Appeal Decision

Decision date: 28th September 2023

Appeal Ref: APP/R5510/D/23/3320742

41 Colne Avenue, West Drayton, Middlesex UB7 7AL

45 degree angle projection first floor plan from neighbouring house no 39 & 43

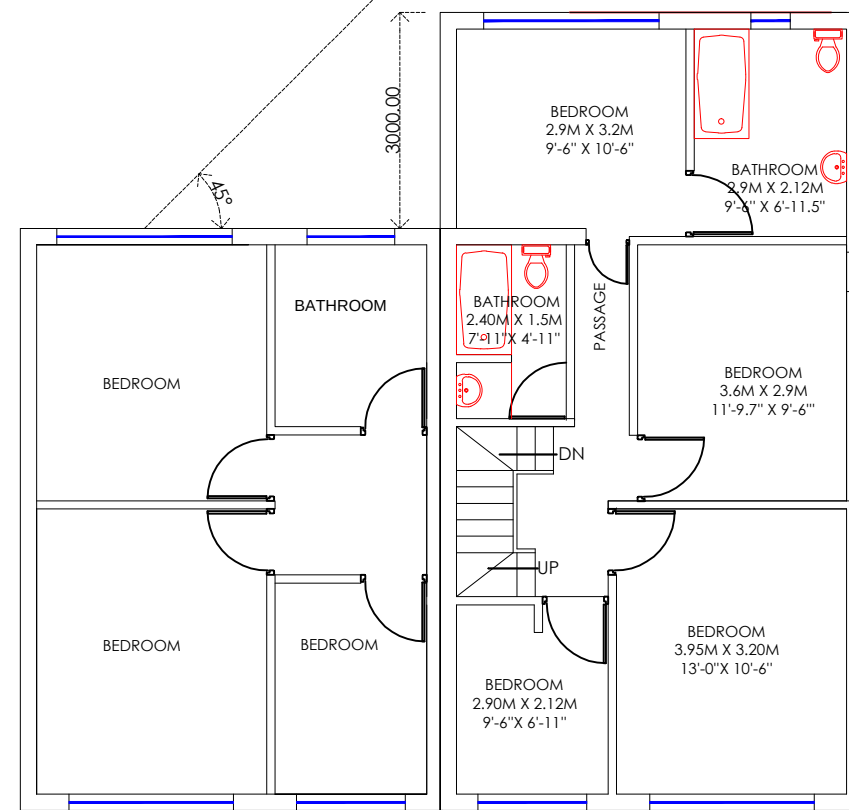
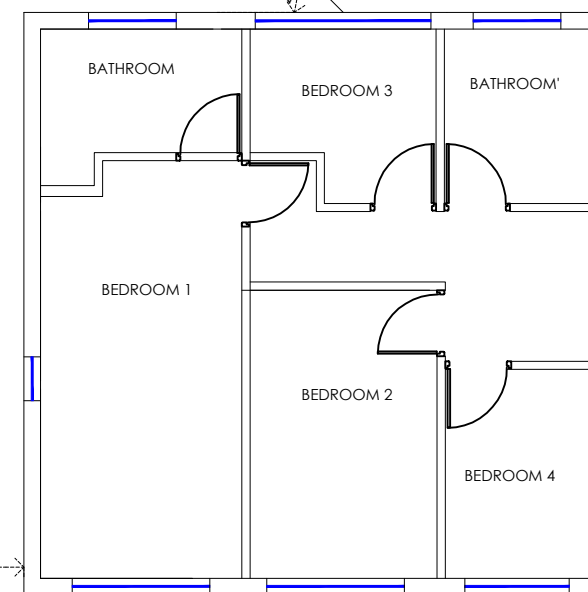
9. The first floor rear extension proposes introducing a side-facing bedroom window in the bedroom currently at the north-western corner of the dwelling. There is a first floor flank window at no.43 Colne Avenue serving a bedroom. These two windows would not be directly opposite one another and, in my view, there would be sufficient offset and distance between the windows to prevent intrusive mutual overlooking. Furthermore, both windows could be opened for ventilation without undue loss of privacy.

10. For these reasons, I conclude that there would not be an unacceptable impact on the living conditions of the occupants of no.43 Colne Avenue by reason of loss of privacy. There would not be conflict with those parts of policies DMHD 1 and DMHB 11 of LP2 which seek to protect the amenity of neighbours and householders.

Proposed Elevation Plans

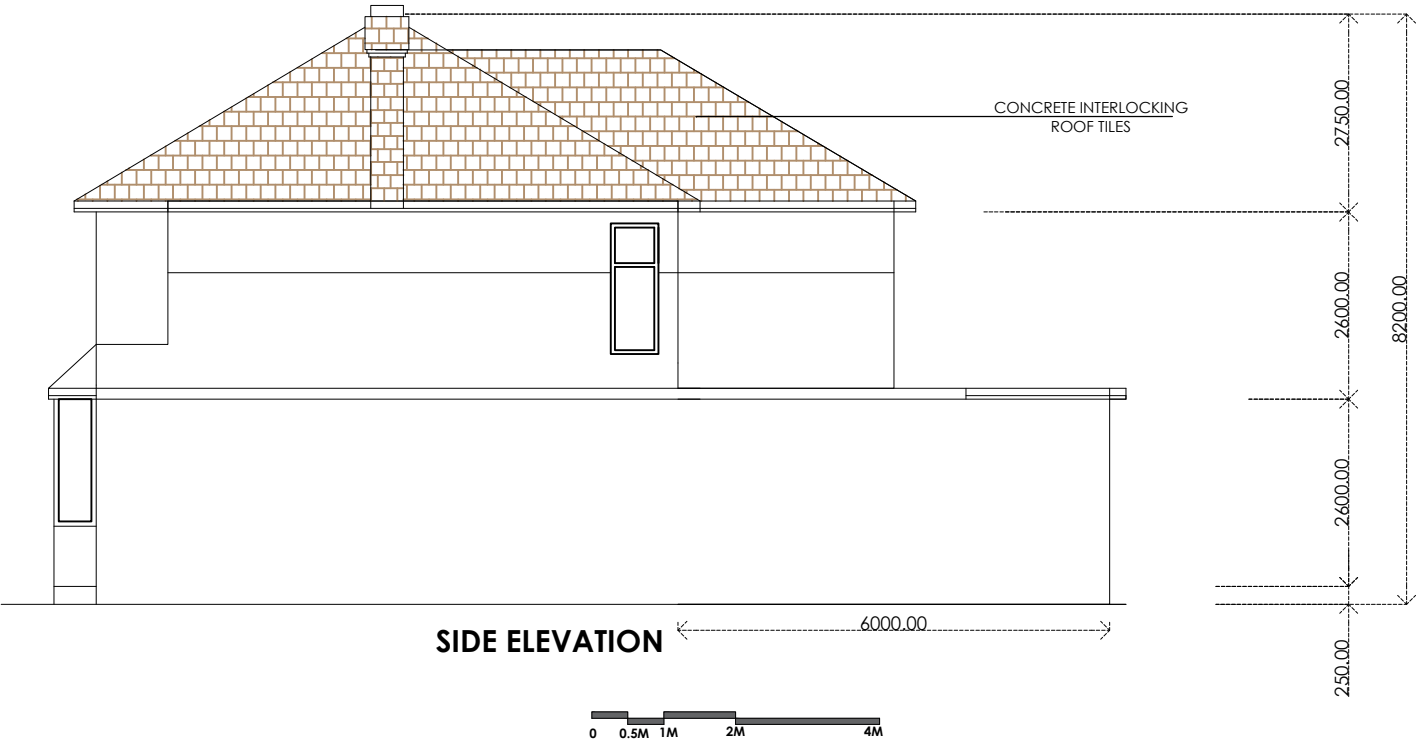
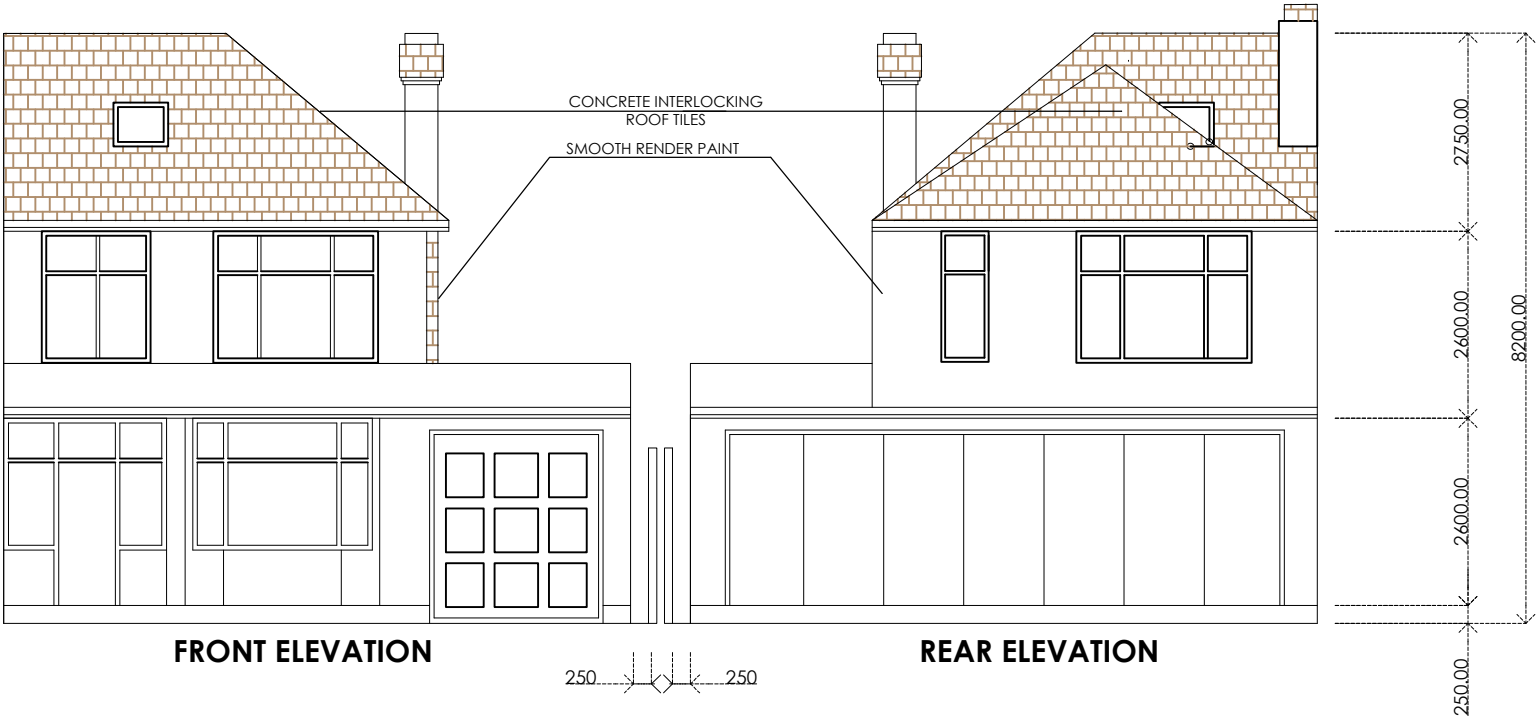
6. The first floor extension would sit partially on top of the ground floor rear extension and would be the same width as the first floor width of the dwelling. It would have a hipped roof with a ridge at a lower level than the ridge of the main roof. A window would be inserted in the existing north (side) elevation which serves a bedroom. The width of the first floor extension would obscure all the first floor main rear elevation and part of the original main roof. This would bring about a significant detrimental change in character to the original dwelling and also result in an overly dominant extension at first floor/roof level in spite of the extension's ridgeline being lower than the main roof.

7. In respect of the loss of character, policy DMHB 5 of the London Borough of Hillingdon Local Plan Part 2 - Development Management Policies (adopted 2020) "LP2" advises that, in Areas of Special Local Character, alterations should respect the established scale, building lines, height and design of the area and that extensions to dwellings should be subservient to and respect the architectural style of the original buildings. Whilst ground floor extensions tend to be less disruptive of original design, first floor extensions are often more difficult to integrate, especially on semi-detached dwellings. In this case, I find the first floor extension would not be sufficiently subservient and would not respect the architectural style of the original building. I have noted that roof pitches on extensions should be a similar pitch to that of the original roof (and in this case they would be similar) but roofs must also be subordinate to it in overall design. I find that the proposed roof including its pitch would not be subordinate in design or appropriately sympathetic in design to the original dwelling. I come to the same conclusion on the first floor rear extension as a whole.

8. Consequently, on the first issue, I conclude that the proposed first floor extension would harm the character and appearance of the host dwelling and in turn there would be some harm to the character of the Area of Special Local Character. It would conflict with policies BE1 and HE1 of the Hillingdon Local Plan Part 1 - Strategic Policies (adopted 2012) "LP1", policies DMHB 5, DMHB 11 and DMHD 1 of LP2 and policy D3 of the London Plan 2021.
